Subject: RE: Planning Consultation on: Y/57/21/PL

Engineers Comments Regarding Surface Water Drainage

Application No: Y/57/21/PL
Registered: 6th May 2021
Site Address: Sunnymead North End Road Yapton BN18 0DL
Grid Reference: 498169 104354
Description of Works: Demolition of existing dwelling and outbuildings and erection of 5 dwellings comprising 2 No 4 bed houses, 3 No 3 bed house (resubmission following Y/33/20/PL). This site is in CIL Zone 3 & is CIL Liable as new dwellings.

Birdseye

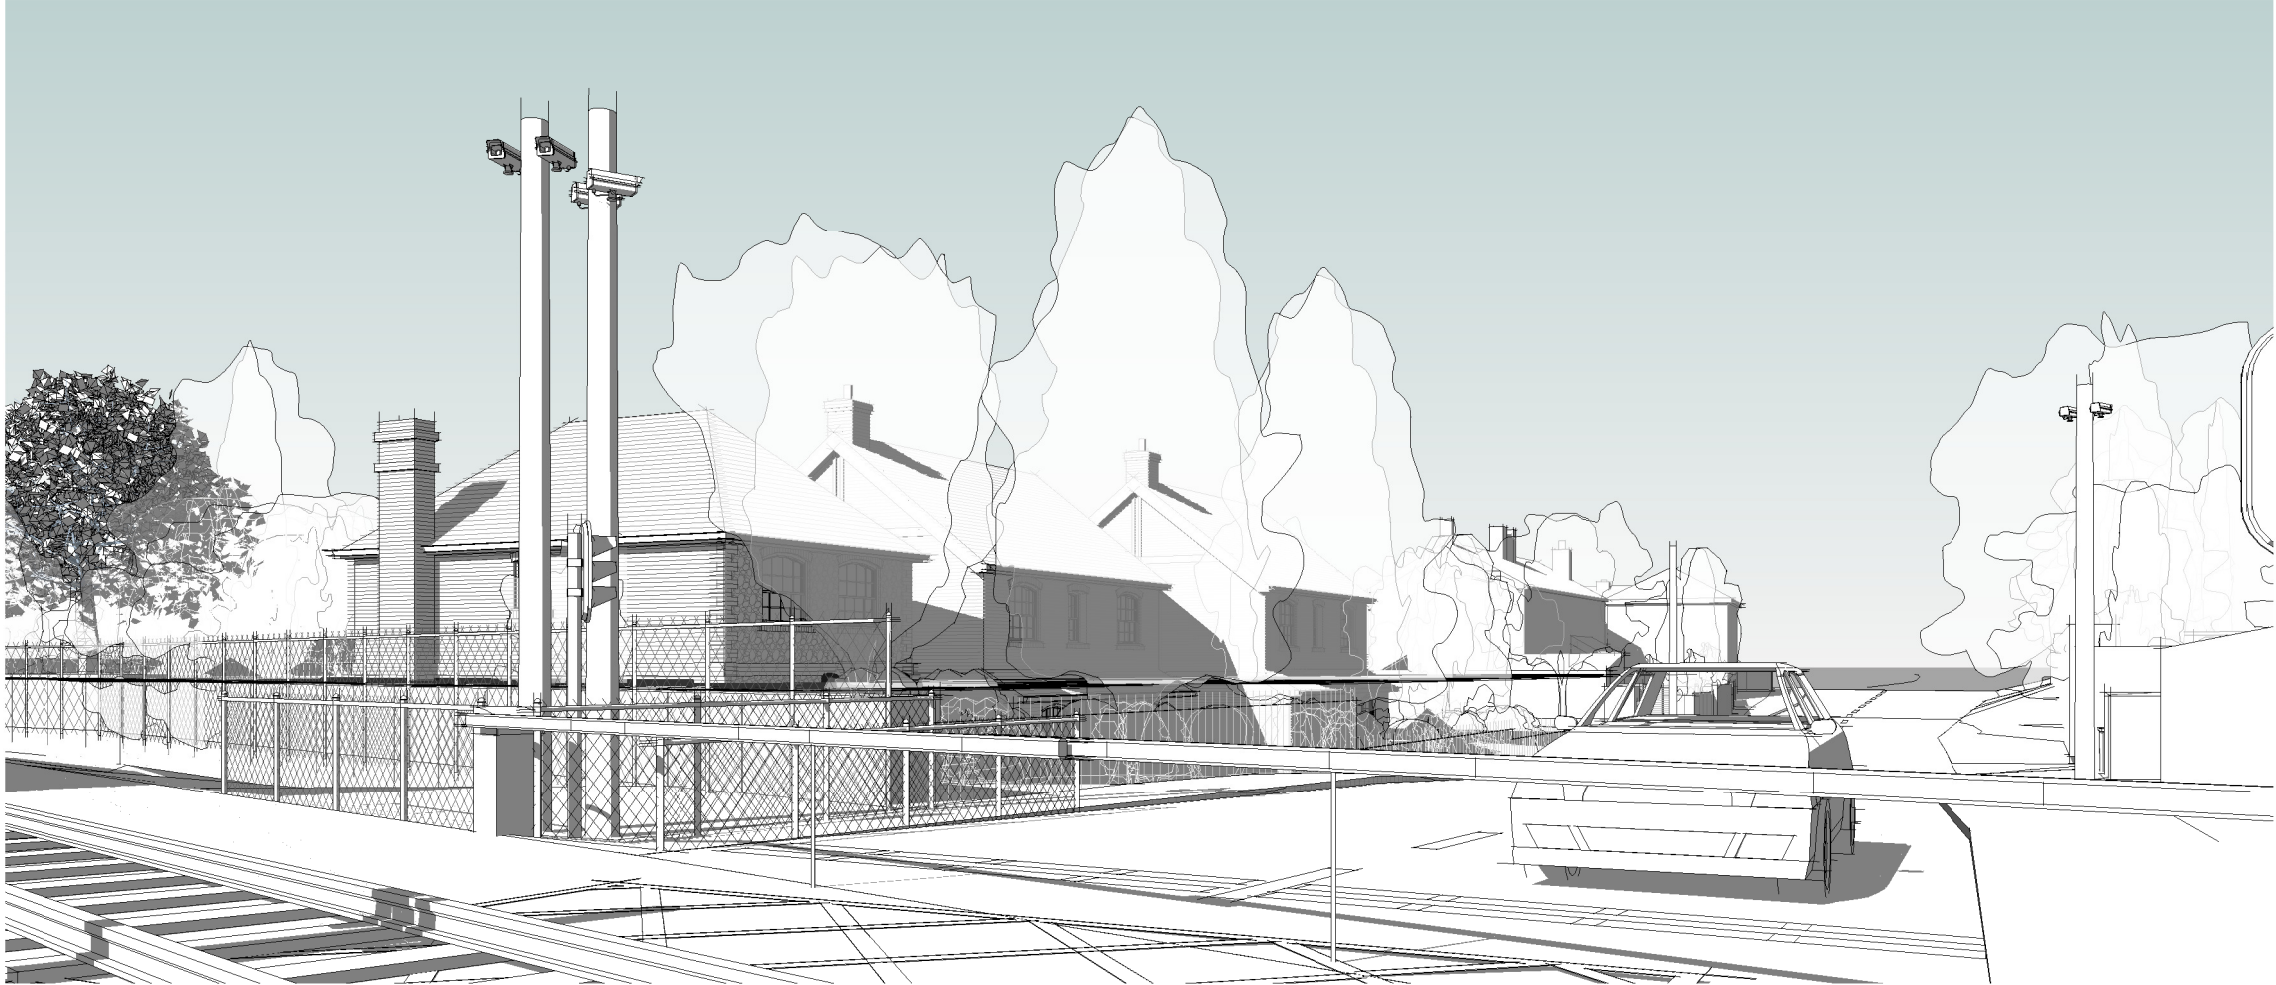
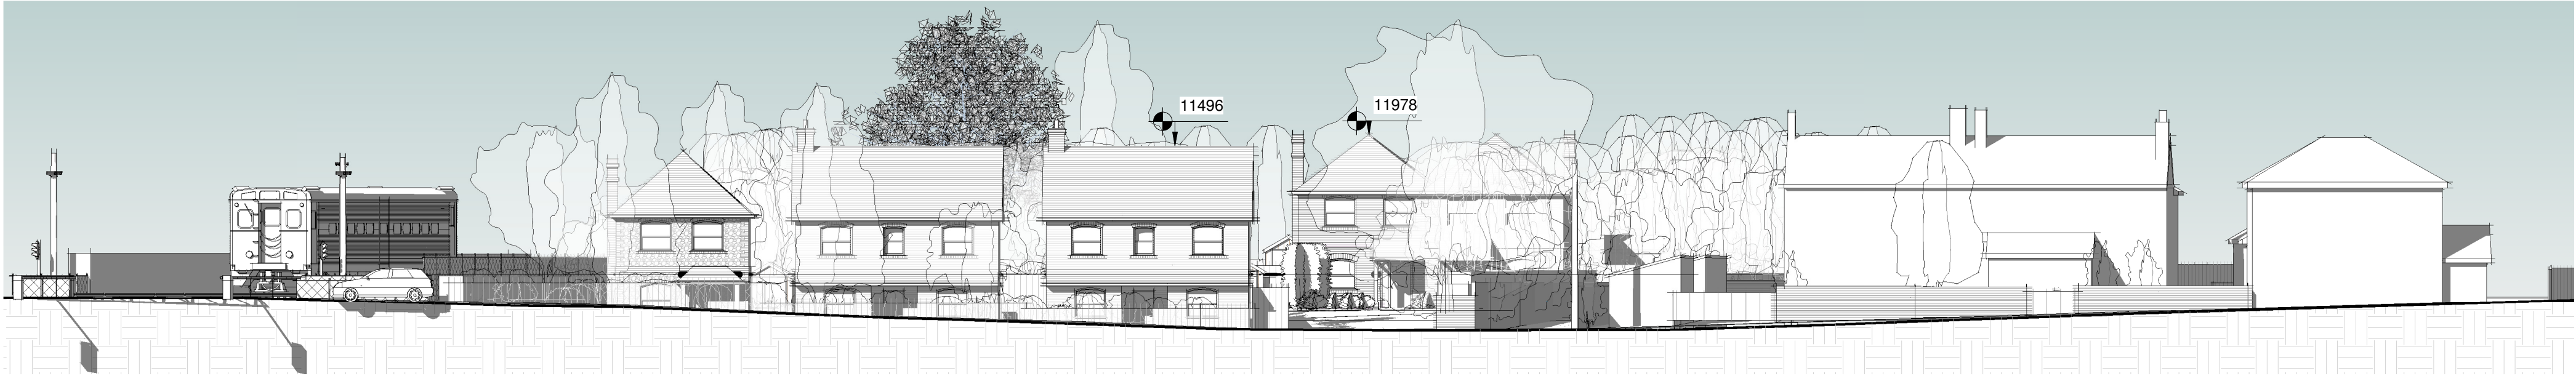
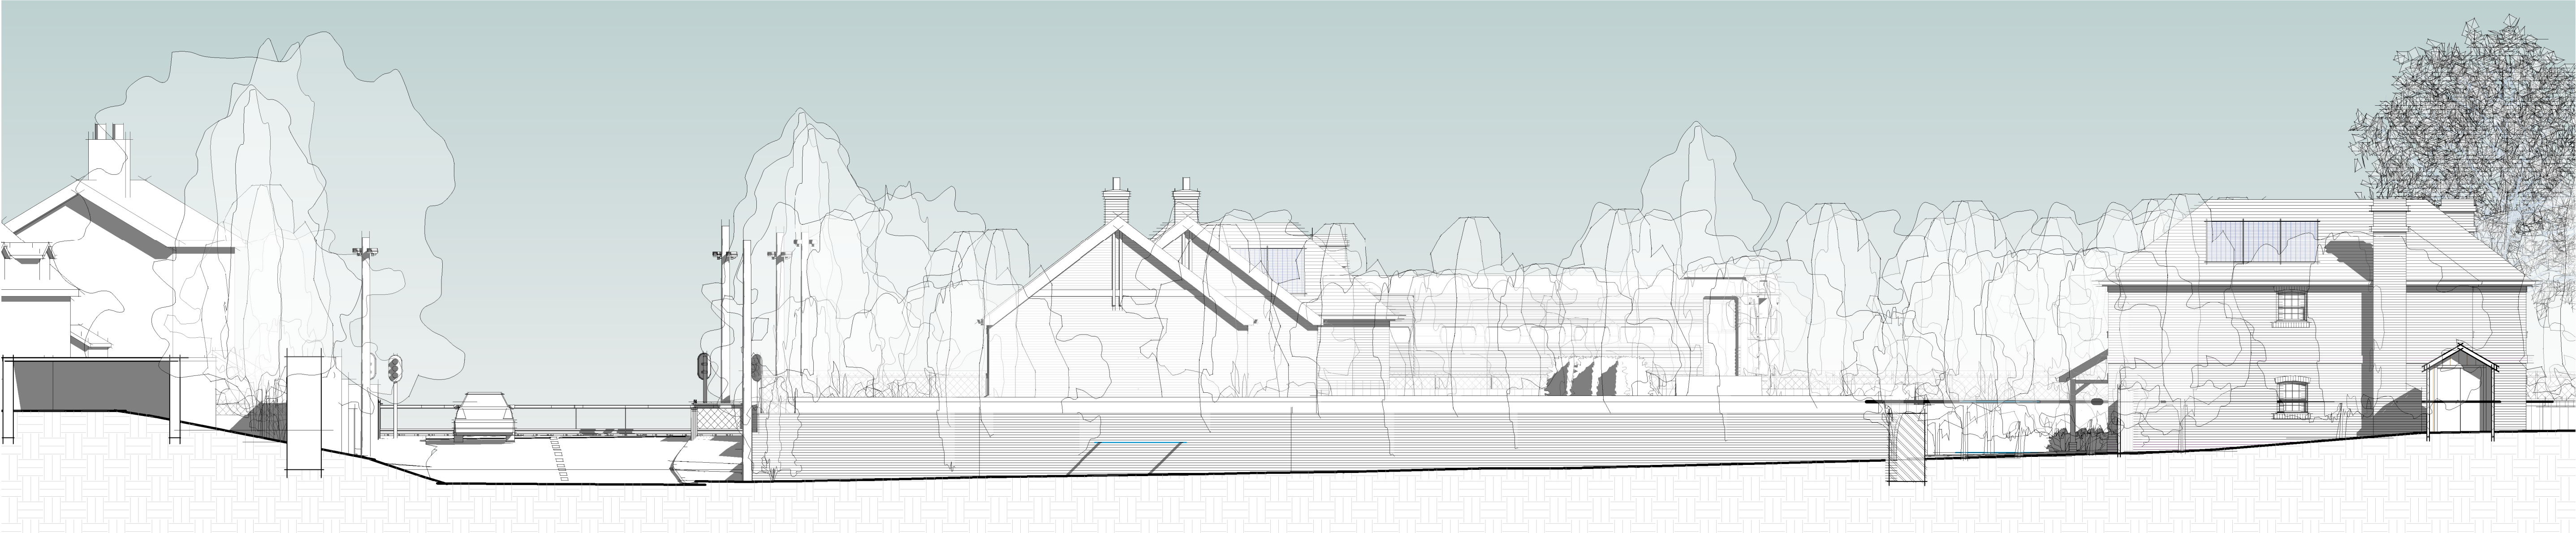
6. It is important that all the documents provided to support the application are consistent. The 3D images which have been submitted do not appear to reflect the level changes which are proposed within the Drainage Strategy

Report. These should be altered to show the reality of the proposed development or removed.

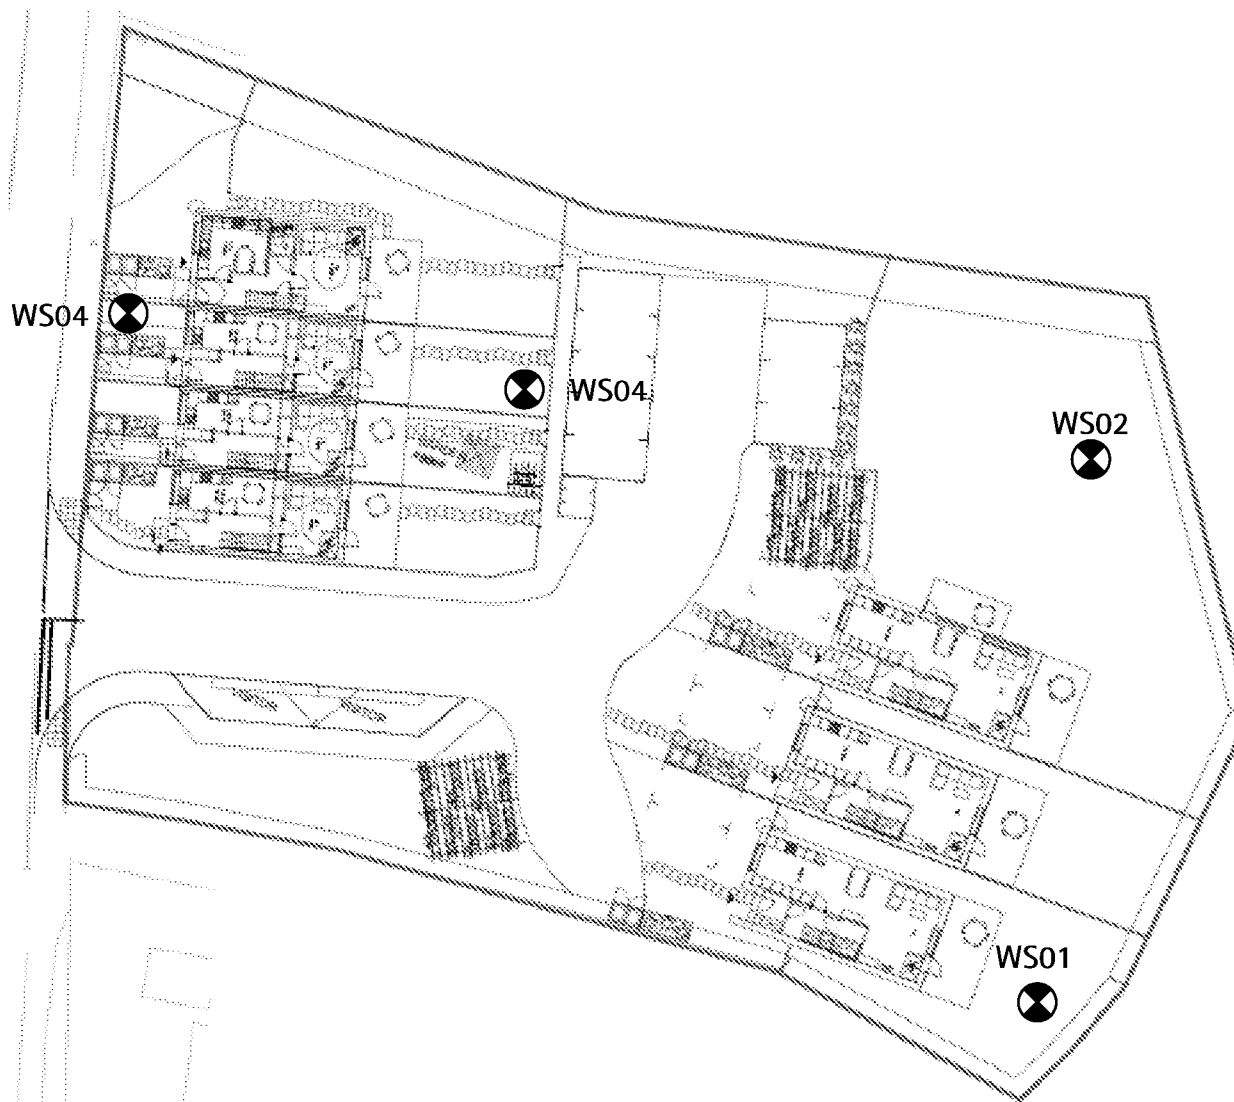
4. (As per previous consultation): Infiltration testing was completed in October and not in accordance with BRE365. The applicant will need to carry out winter infiltration tests in strict accordance with BRE365, in the locations and at the depths of any proposed infiltration structures. It is expected that this will include both shallow and deeper tests to account for the permeable paving and the proposed soakaways. The testing should be undertaken in the months of January/February when the ground is most saturated and above the recorded highest groundwater level (see point 5).
